SOUTH DUBLIN COUNTY COUNCIL'S PLANNING AUTHORITY'S REPORT TO AN BORD
PLEANALA ON APPLICATION FOR

SUBSTITUTE CONSENT UNDER SECTION 261A

AT BEHAN'S QUARRY WINDMILL HILL, RATHCOOLE

Date of Report: 18th August 2021

Drawing file: 03 - Substitute Consent Drawings / 310461 - 32 - Storage Drying Shed - 100 A0.pdf

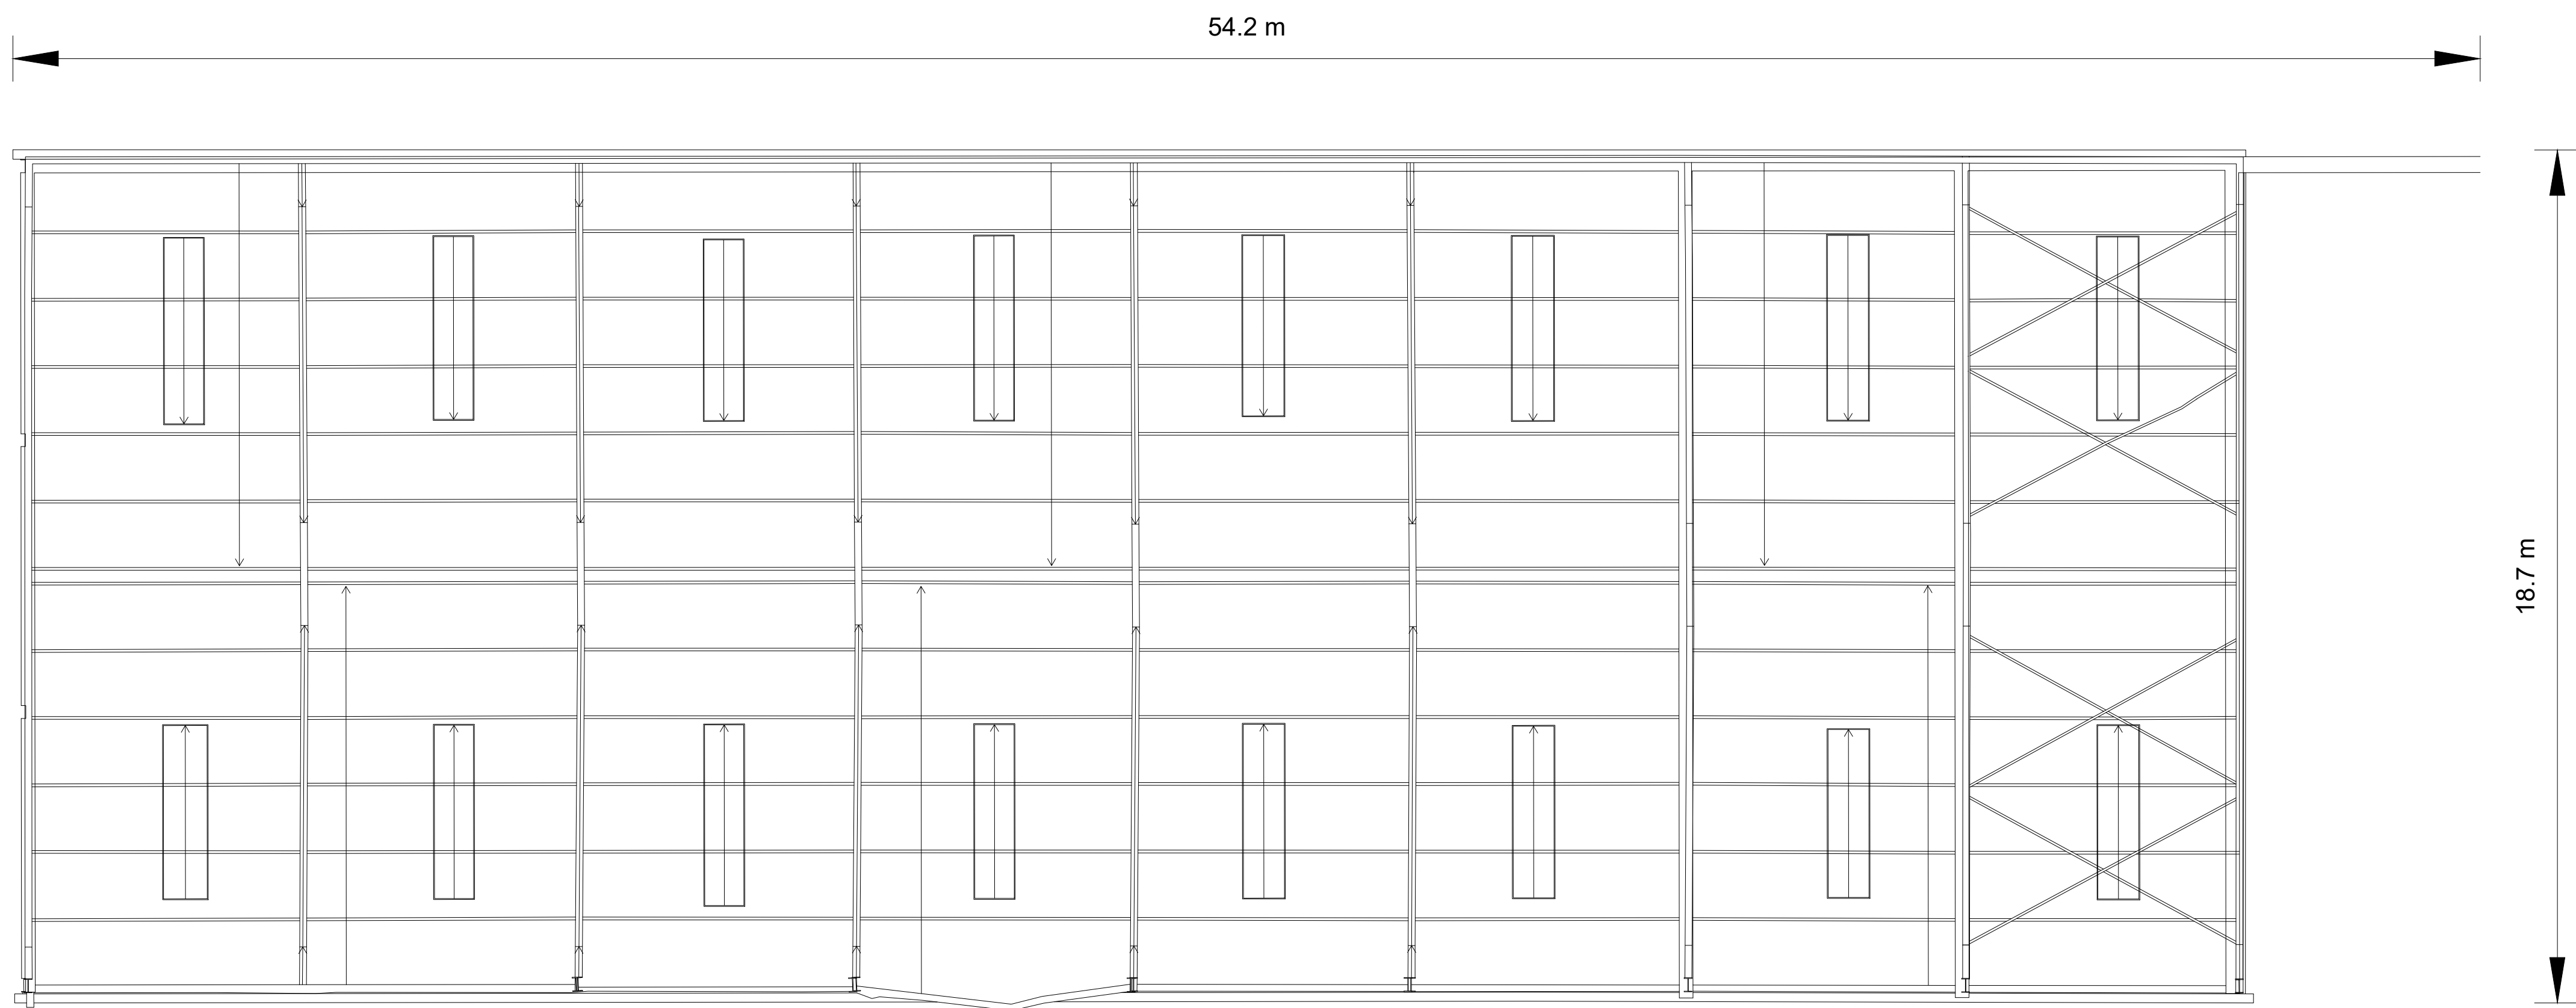
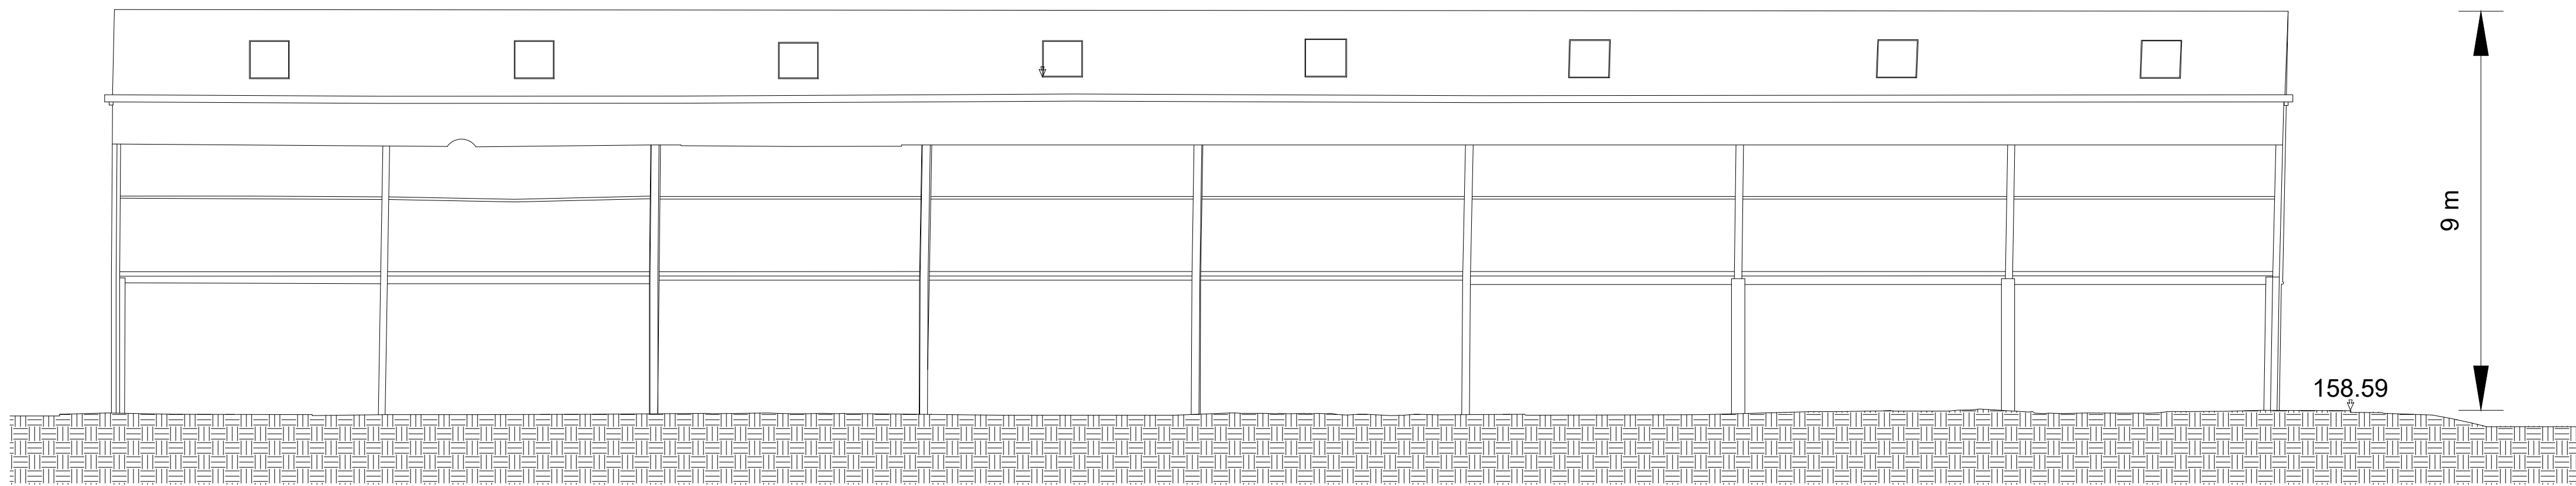
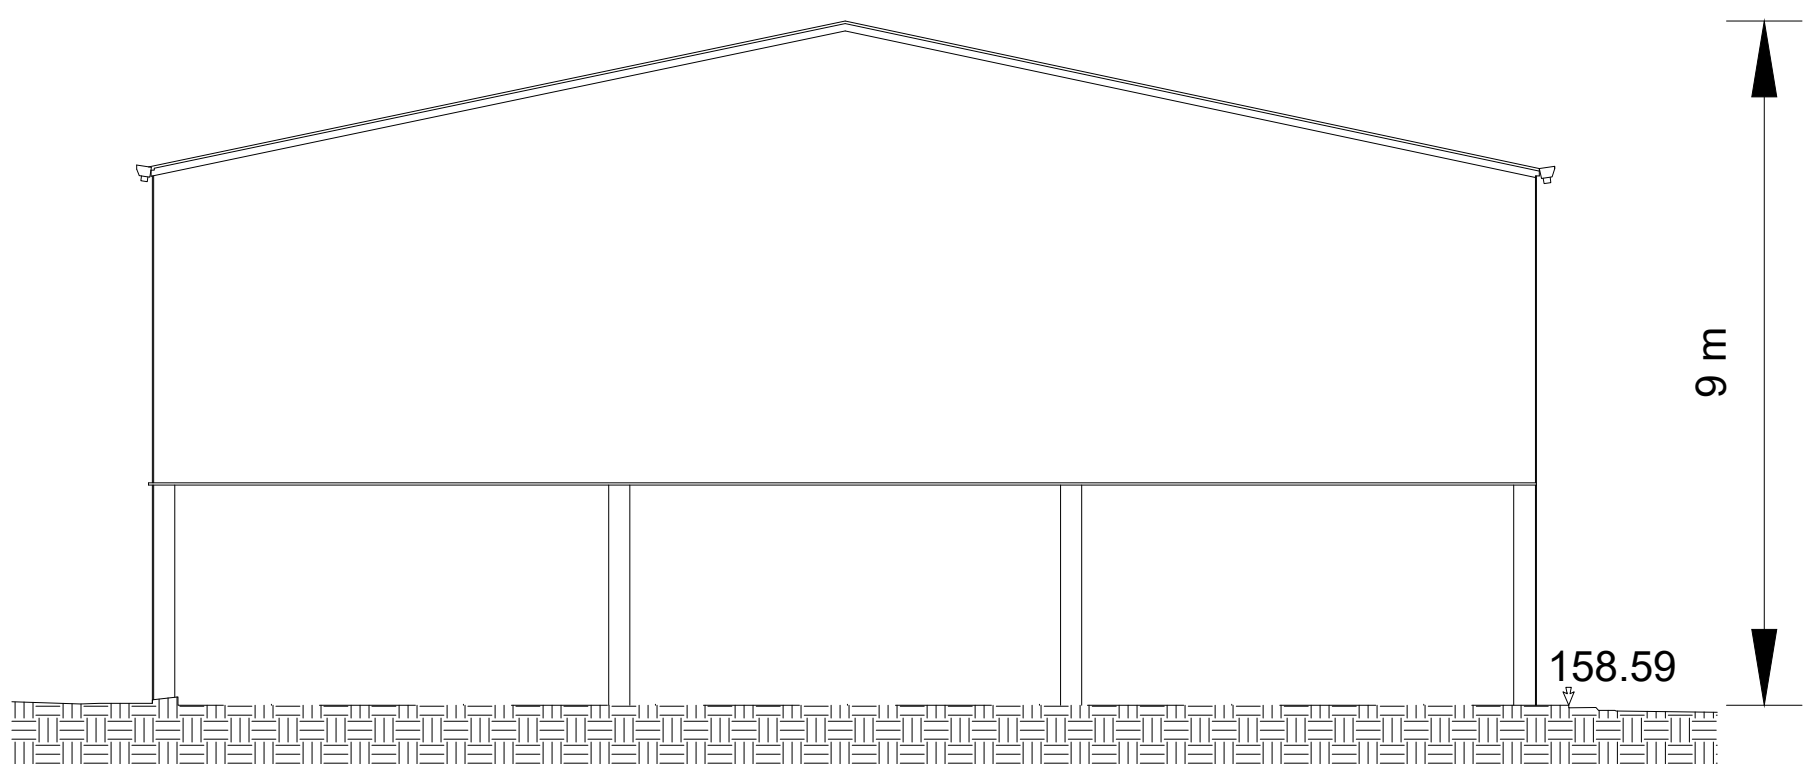
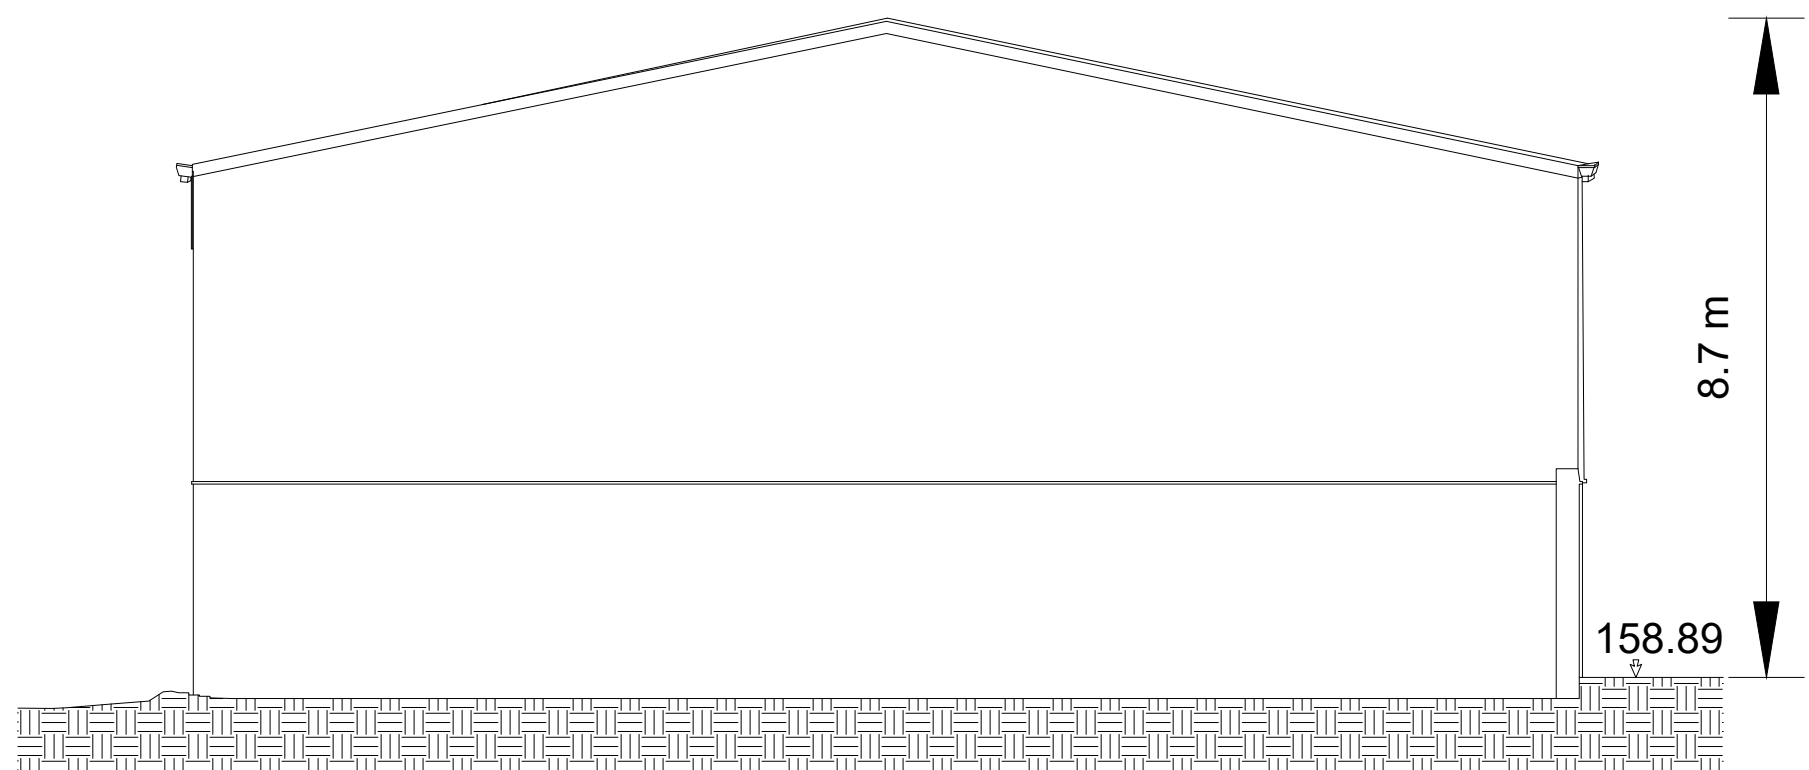
- 2.5 **Note:** A storage/drying shed and a concrete plant, located within the administration and plant processing area that do not hold pre 1963 or exempted development status require regularisation. These items, existing within lands that hold development for which an EIA is required, require a regulating planning consent.

- iv. A storage/drying shed and a concrete plant, located within the administration and plant processing area that do not hold pre 1963 or exempted development status are excluded from this SC application under S261A.

- c. 4 x containers,
- d. 2 x storage/maintenance sheds,
- e. a storage/drying shed,
- f. water recycling unit and silt press,
- g. a concrete plant and washing, crushing, screening and bagging plants
